W-2011-39  
March 24, 2016

**Re: Proposed Parking Lot Improvements – Whole Foods Market  
160 Fox Street, Portland, Maine**

**Level I Site Plan Development Review Application**

**A. Reviewer: Woodard & Curran  
Date: March 17, 2016**

SITE PLAN

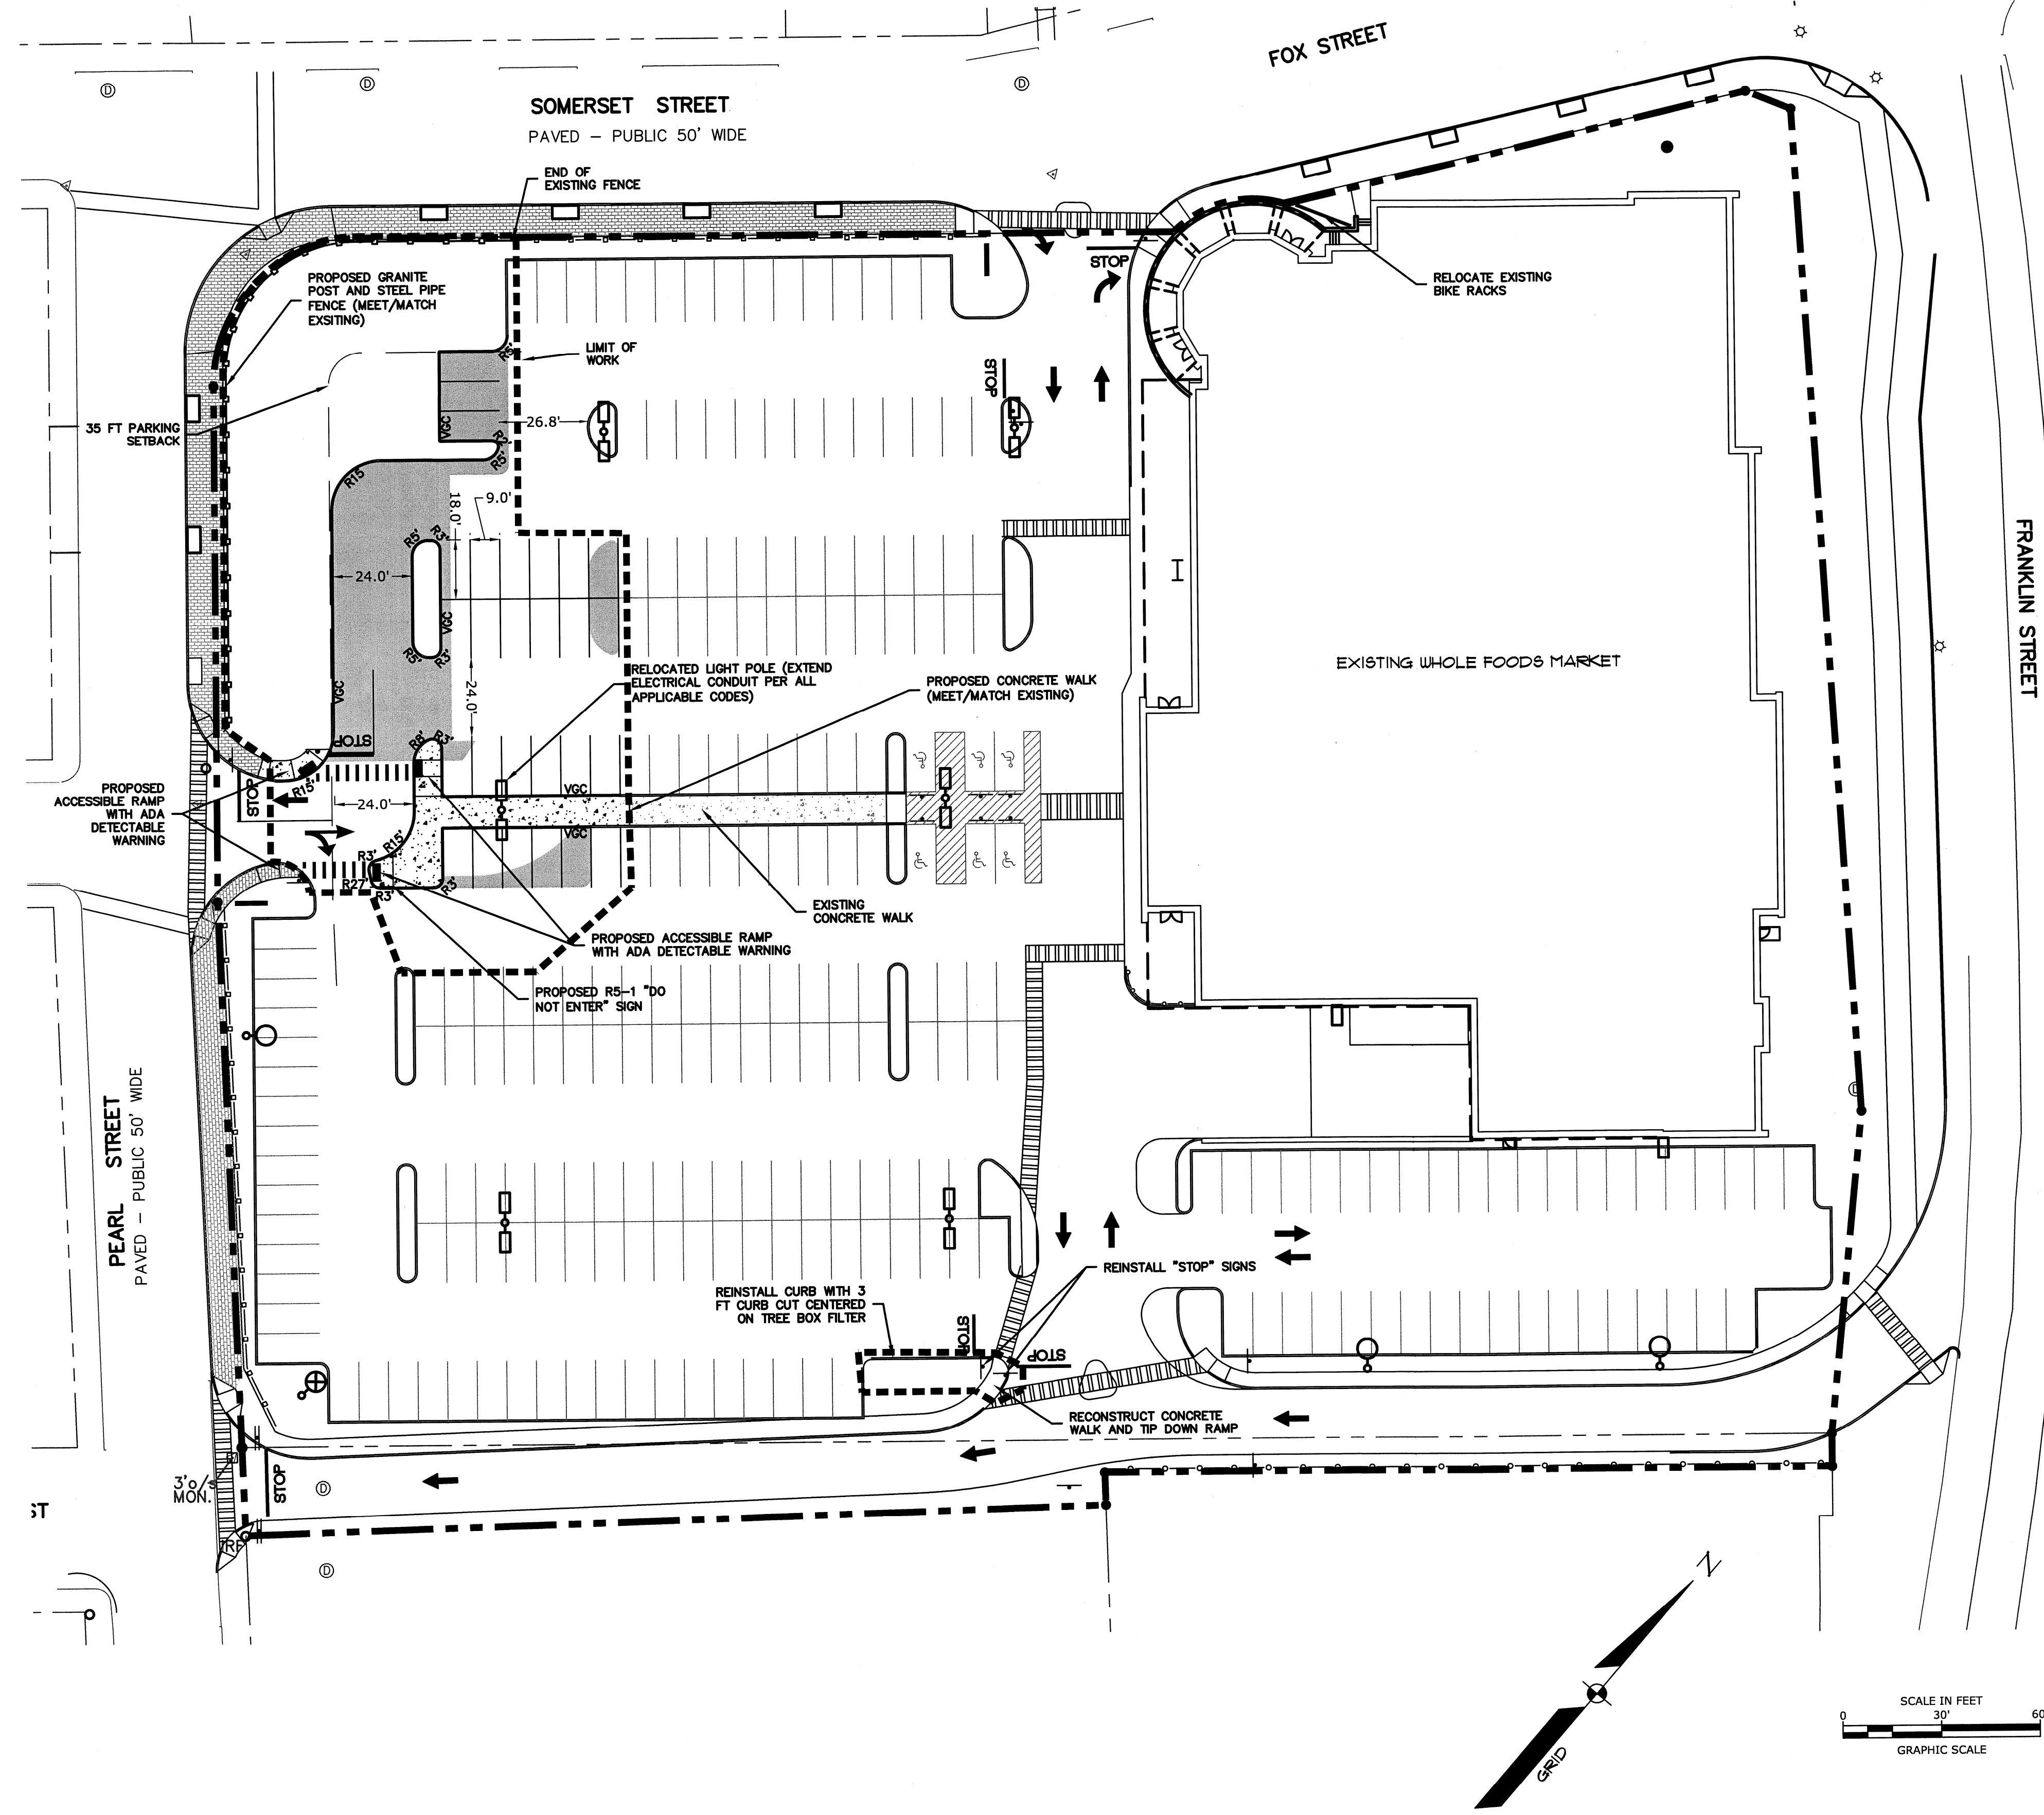
2. *City staff wants the existing bike racks moved from the parking area along Lancaster Street to the café entrance.*

**The bike racks have been called out to be relocated.**

GRADING, DRAINAGE, AND EROSION CONTROL PLAN

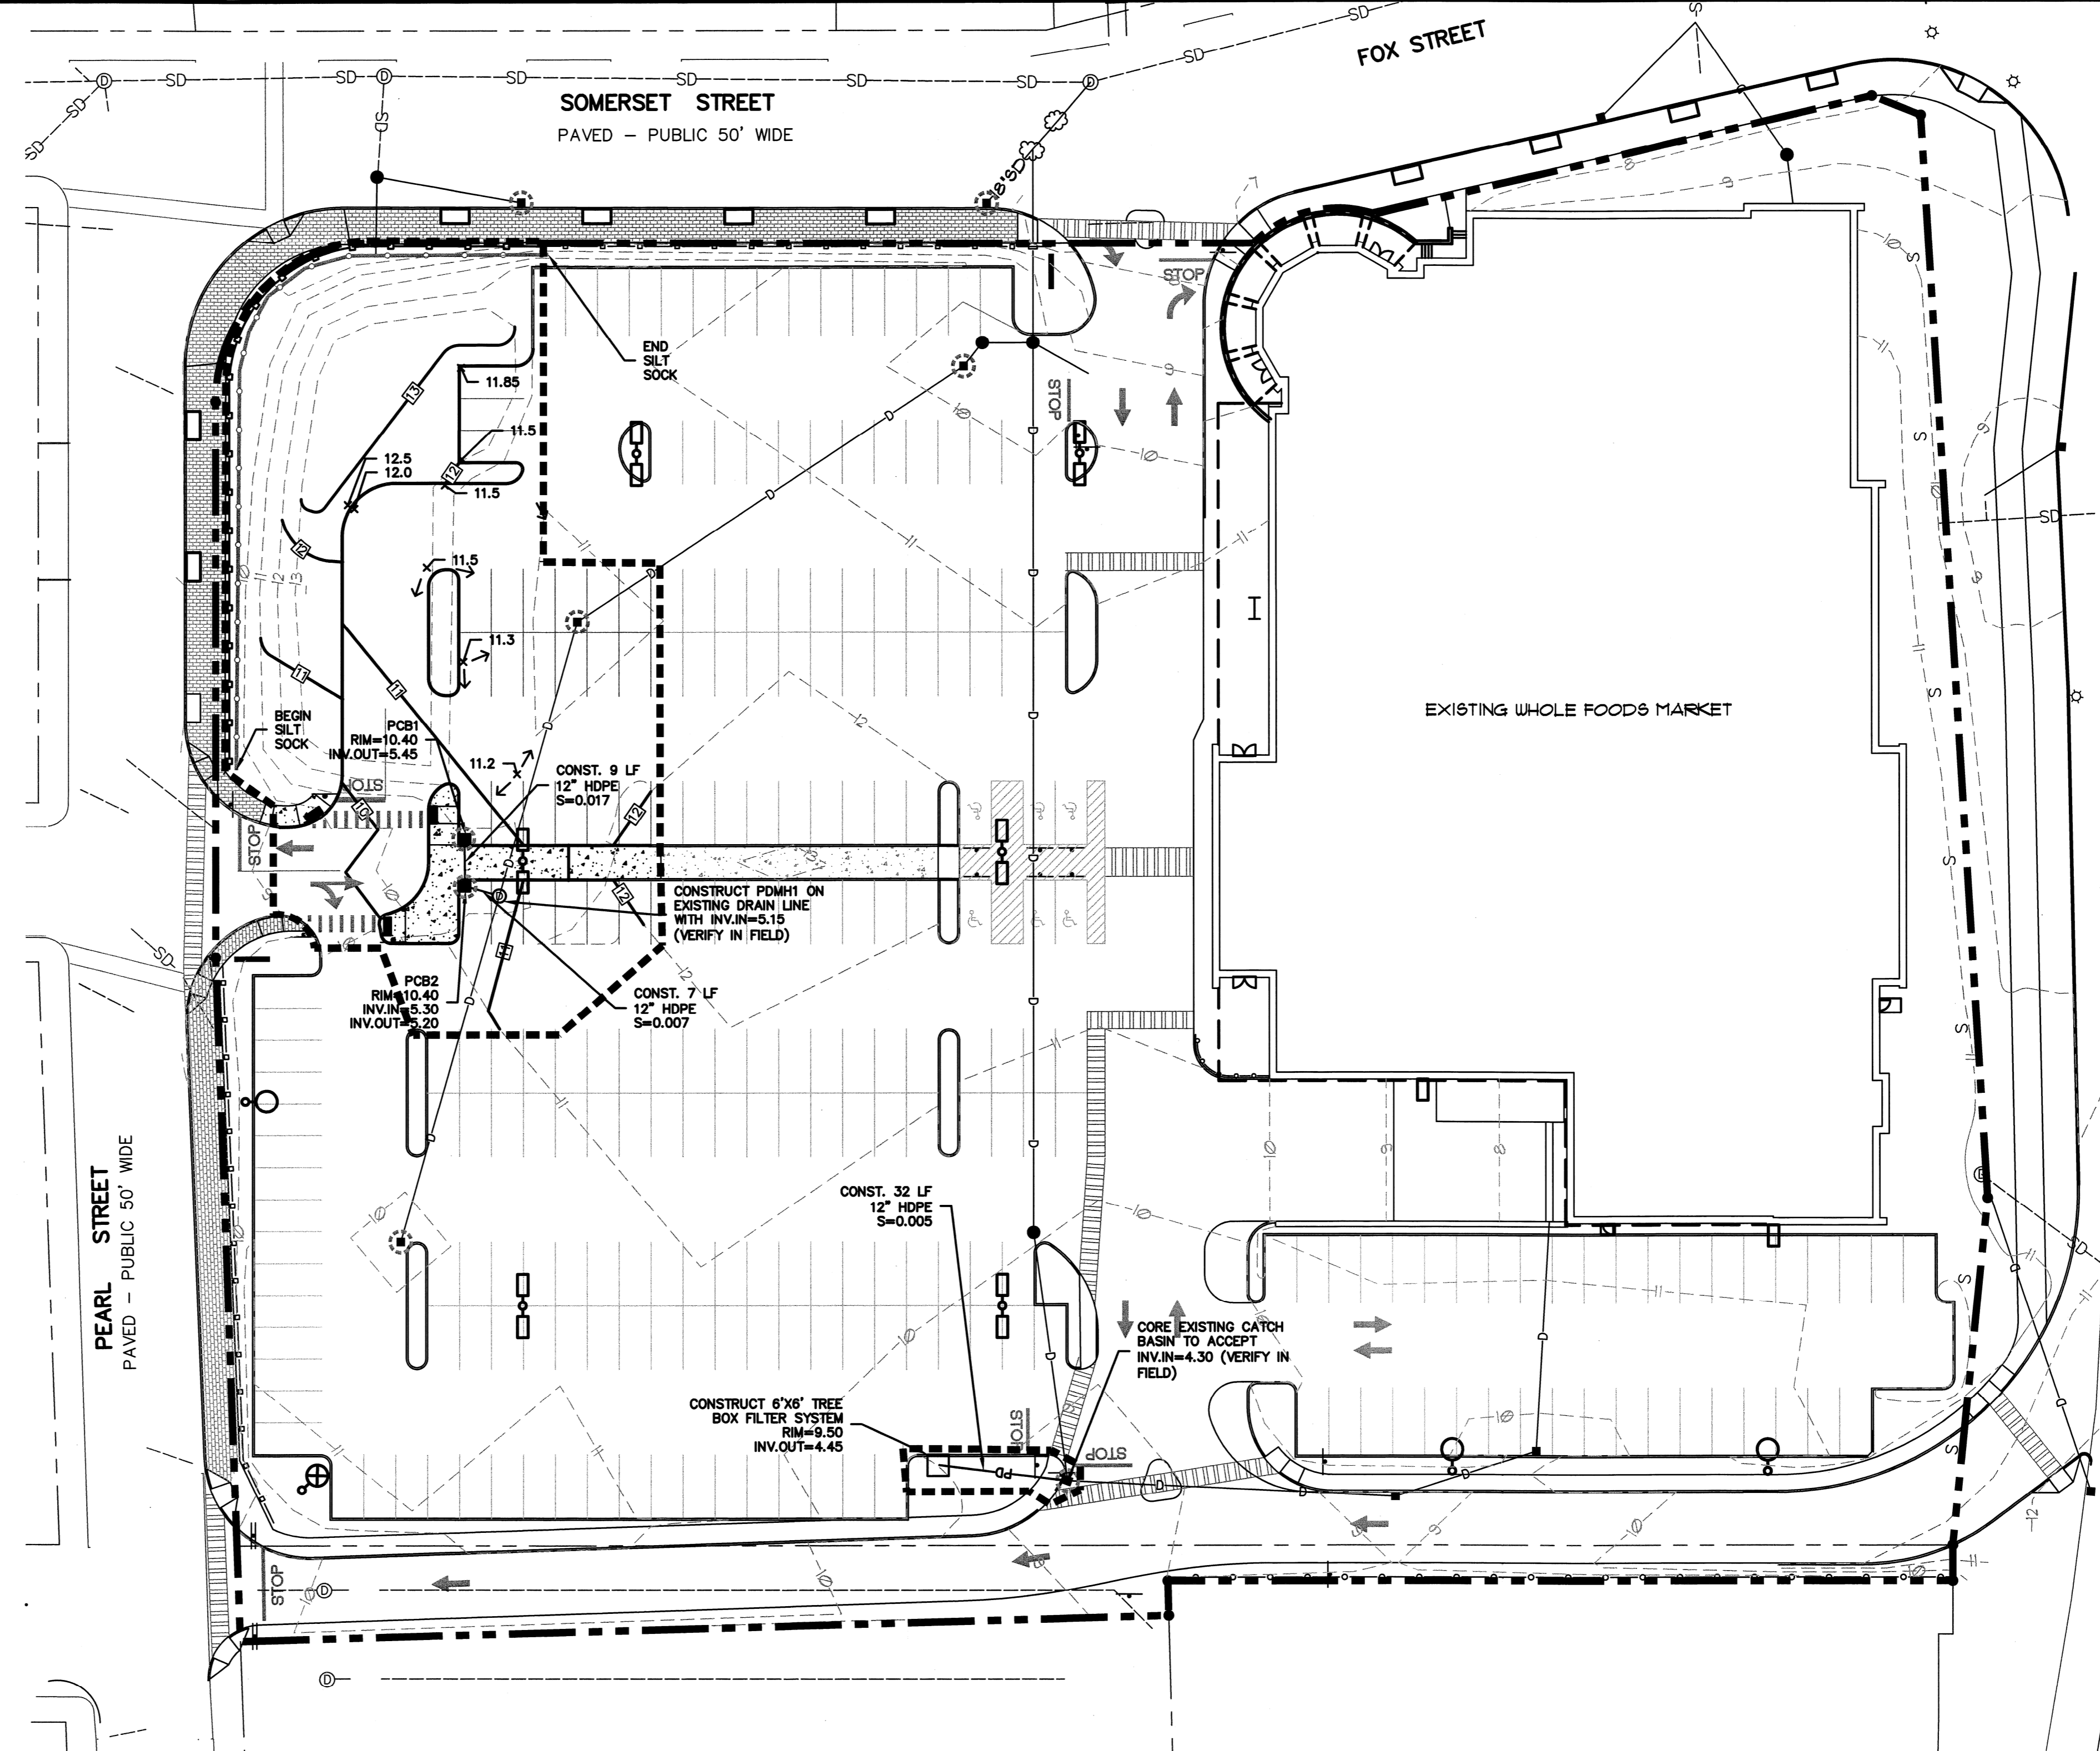
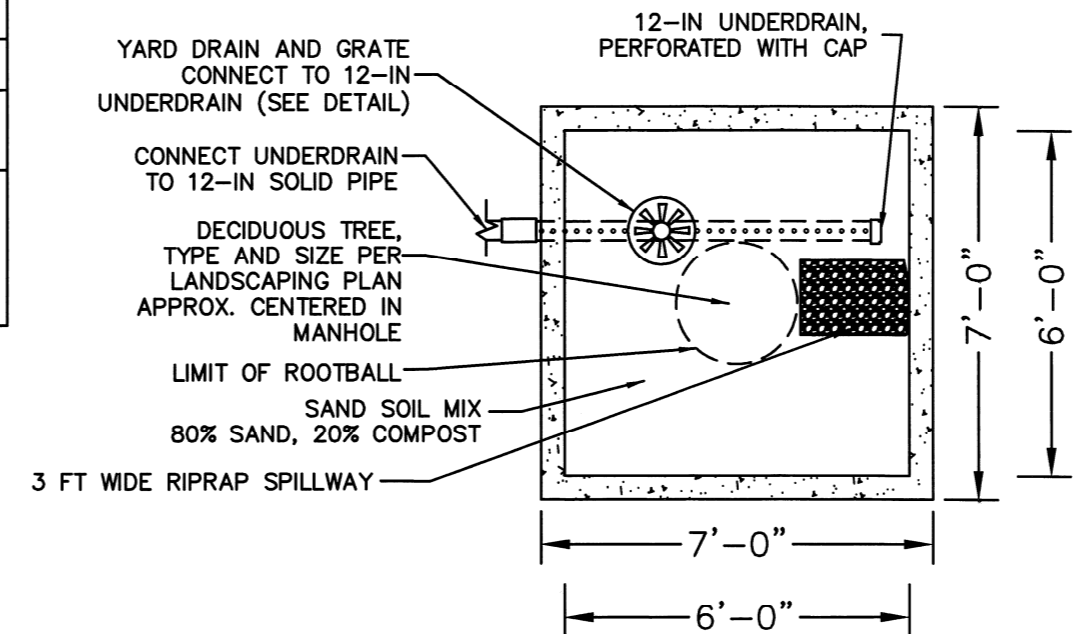
**No modification necessary.**
  - b) *General Standards: ...the Applicant will be required to install a stormwater quality treatment measure that meets the MaineDEP Chapter 500 General Standards for treatment of an impervious parking lot area equivalent to the proposed expansion (note that the Applicant can elect to treat a different area of the parking lot, so long as an equivalent area is managed). Sizing calculations should be provided for any proposed stormwater best management practices per MaineDEP guidance. An inspection and maintenance plan should be prepared and submitted following MaineDEP guidance, with reference to the City's annual inspection and reporting criteria, as outlined in Chapter 32 of the City of Portland Code of Ordinances.*

**A tree box filter has been proposed near the Lancaster Street entrance to the parking lot. A tree box filter exhibit has been provided to show the contributing area, sizing criteria, and inspection, maintenance, and reporting requirements.**
